From: Chloe Dunlop
Sent: Wednesday, 14 February 2018 3:29 PM
To: 'Shivesh Singh'
Cc: 'Bradley Searle'; Kelly McNicol; Chris Ritchie
Subject: Comments on Bingo Minto RTS - SSD 7462
Attachments: SW Response 165523.pdf; Minto Resource Recovery Facility (SSD) 7462 application - RTS; 20180209 Findlay Consulting Engineers - Response to SSD 7462 amended Development Application.pdf; Letter Out - FRNSW Response to Submissio~- 13 Pembury Road Minto - Chloe Dunlop - Department of Planning and Environment.pdf; L&W response - Minto Resource Recovery Facility - RTS.PDF; Invoice for Additional Application Fee -Bingo Minto SSD 7462.pdf

Thank you for coming in to our office recently to discuss the Minto application. Please find **attached** comments from the following agencies regarding the December 2017 RTS:

13 PEMBURY ROAD,
MINTO
LOT 1 DP 1013852

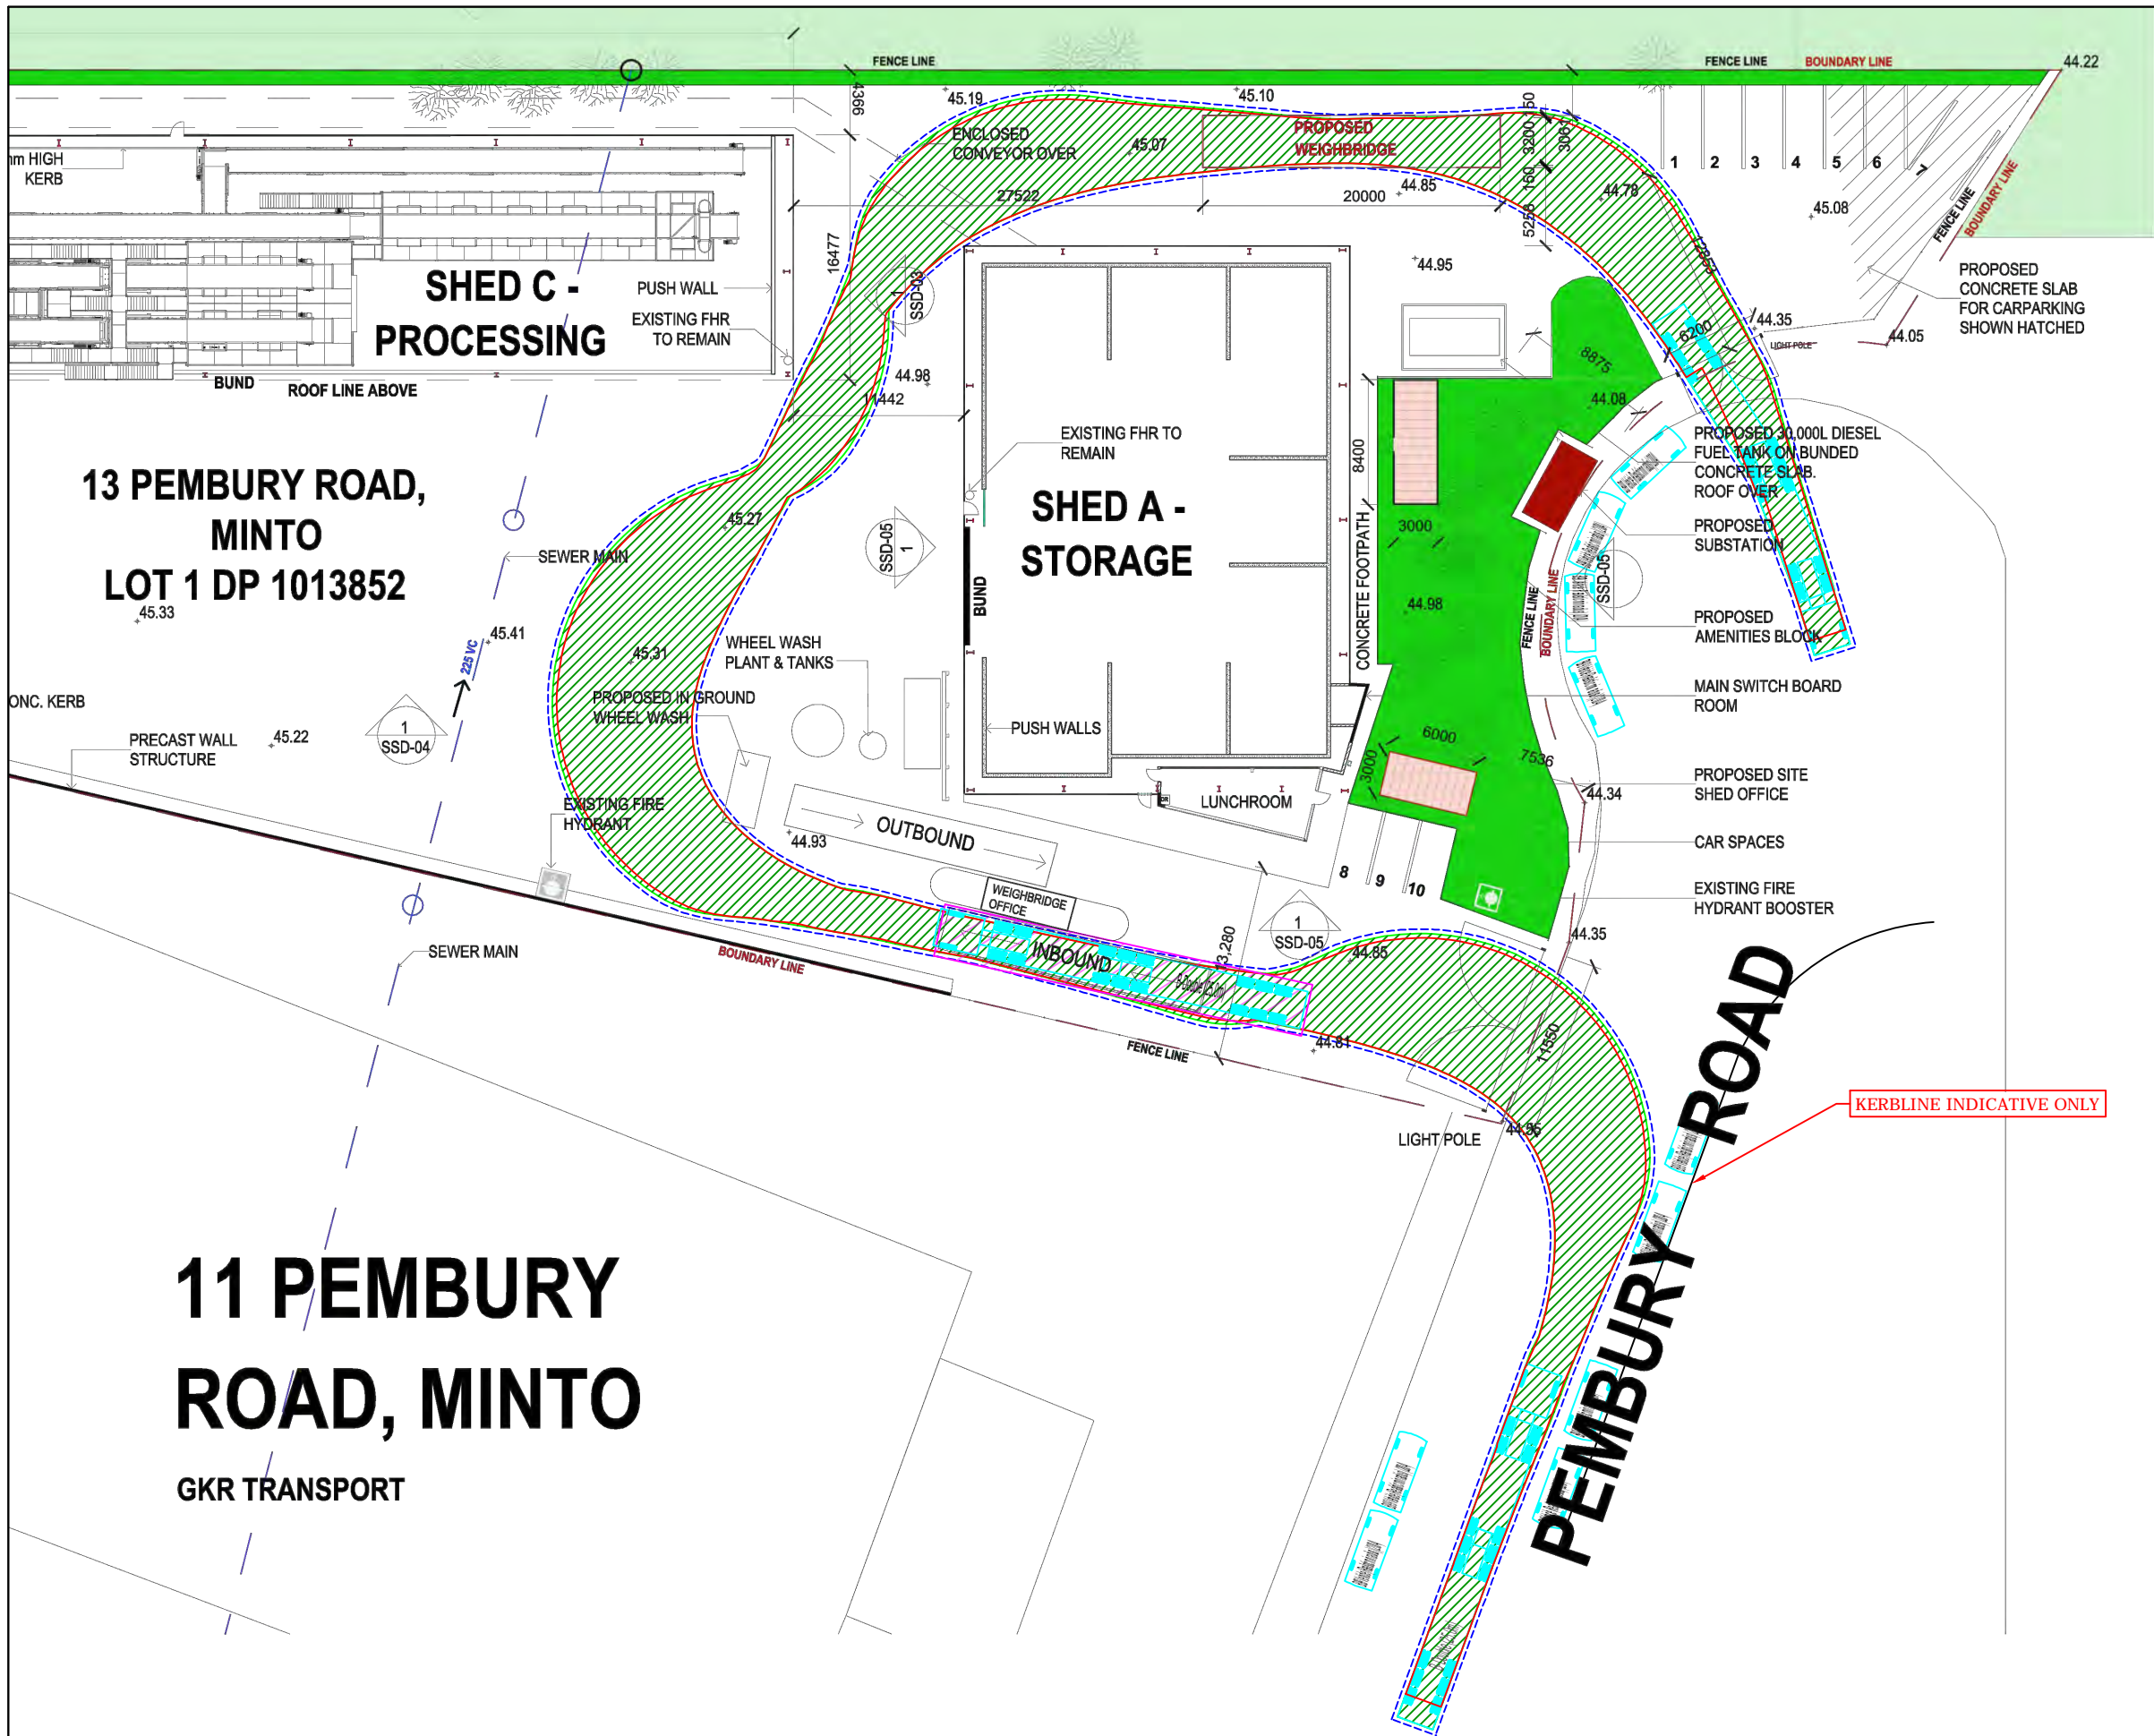
7. At our meeting of 24 January, the Department expressed concern that the swept path diagrams for waste collection trucks will be too tight. Consideration should be given to scheduling waste collection by 25 metre trucks to outside of the early morning peak unloading period to avoid conflicts with other vehicles on-site and the potential for vehicles queuing on Pembroke Road.

**Figure 4 Proposed Flow Diagram – Waste and Vehicle Movements**

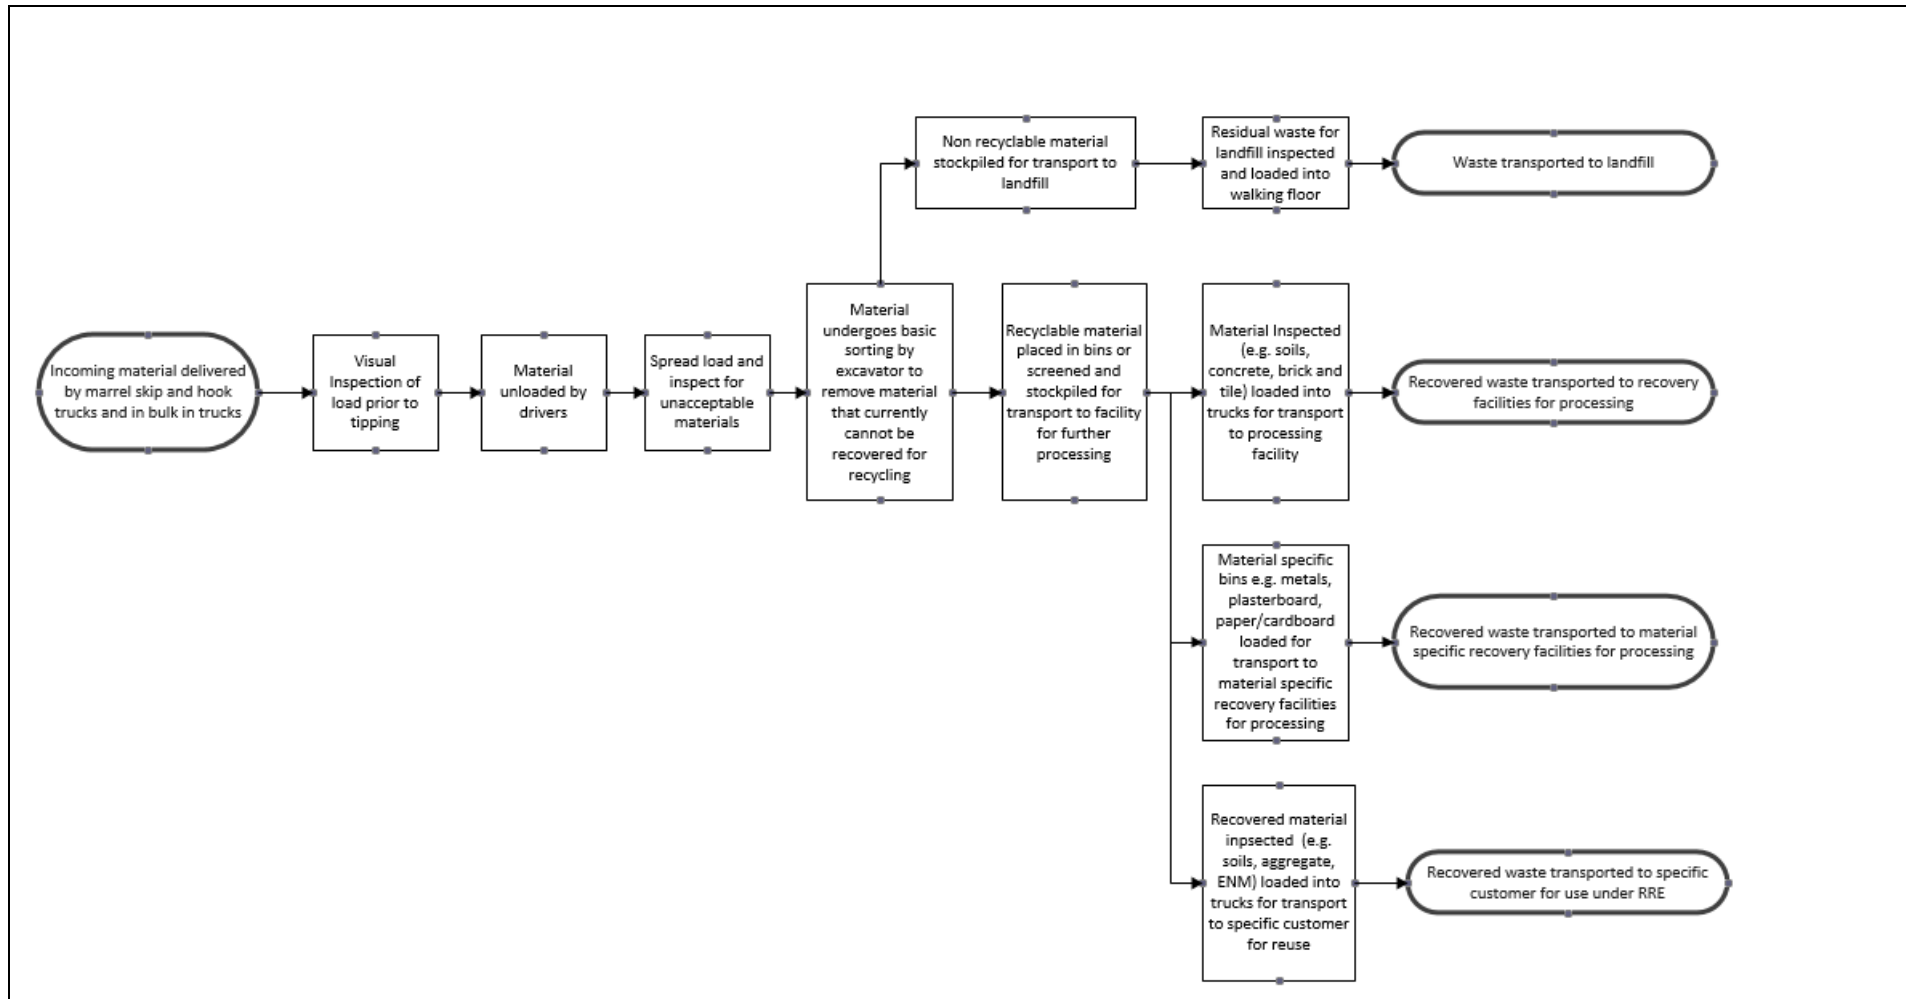
13. It is understood that temporary storage is required for non-conforming (unpermitted) waste items awaiting removal. In line with the EPA's draft *Standards for Managing Construction and Demolition Waste in NSW* (October 2017) (the draft Standards), NCW should be removed from site every day. Please provide updated procedures (as appropriate) demonstrating the Applicant's commitment to adhere to the draft Standards.
14. Update 'Figure 1-2 Minto Processing and Handling Flow Chart' to show unexpected finds.

## STORMWATER PLAN

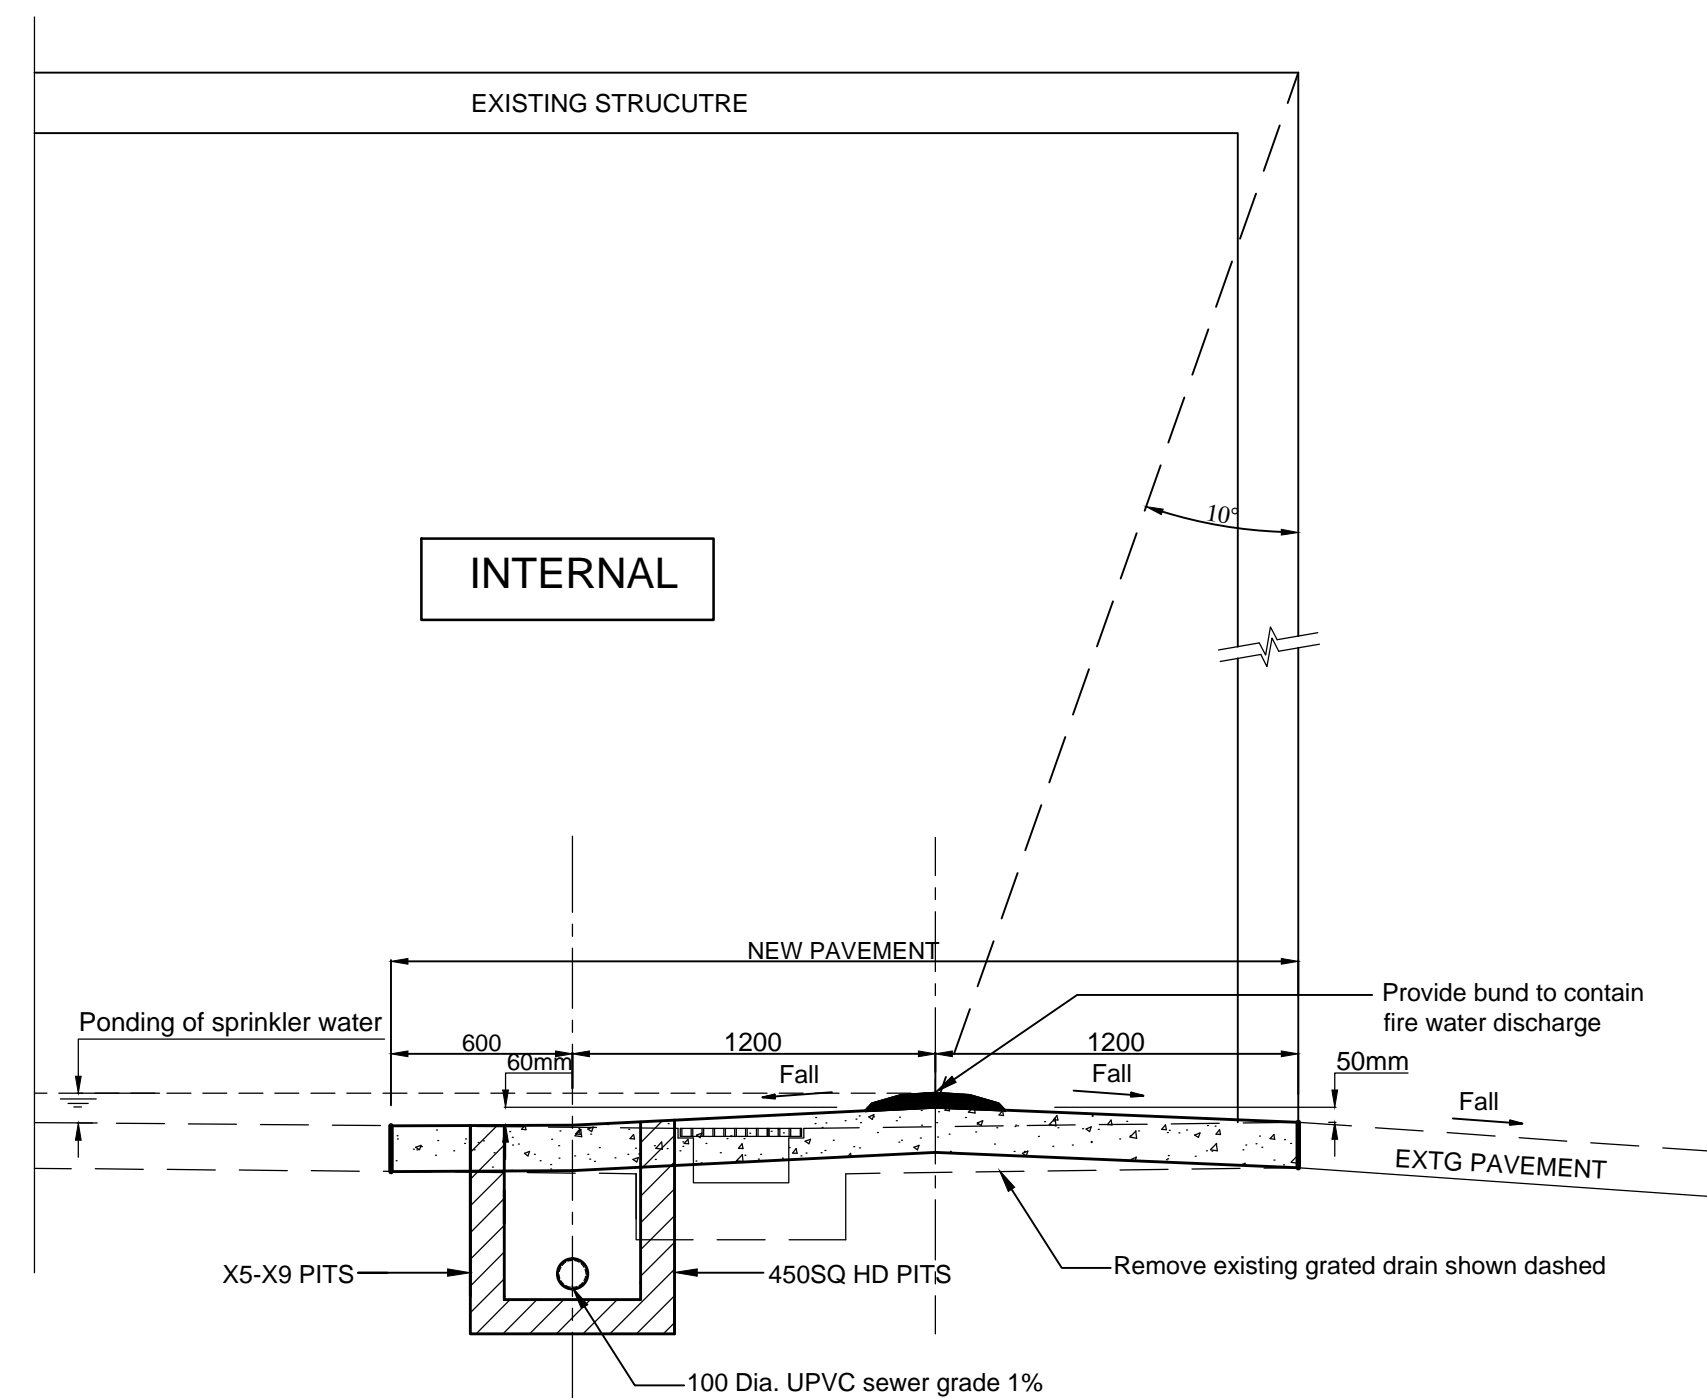
9. Provide further details and updated plans showing how leachate from within the processing shed will be contained and separated from other stormwater.
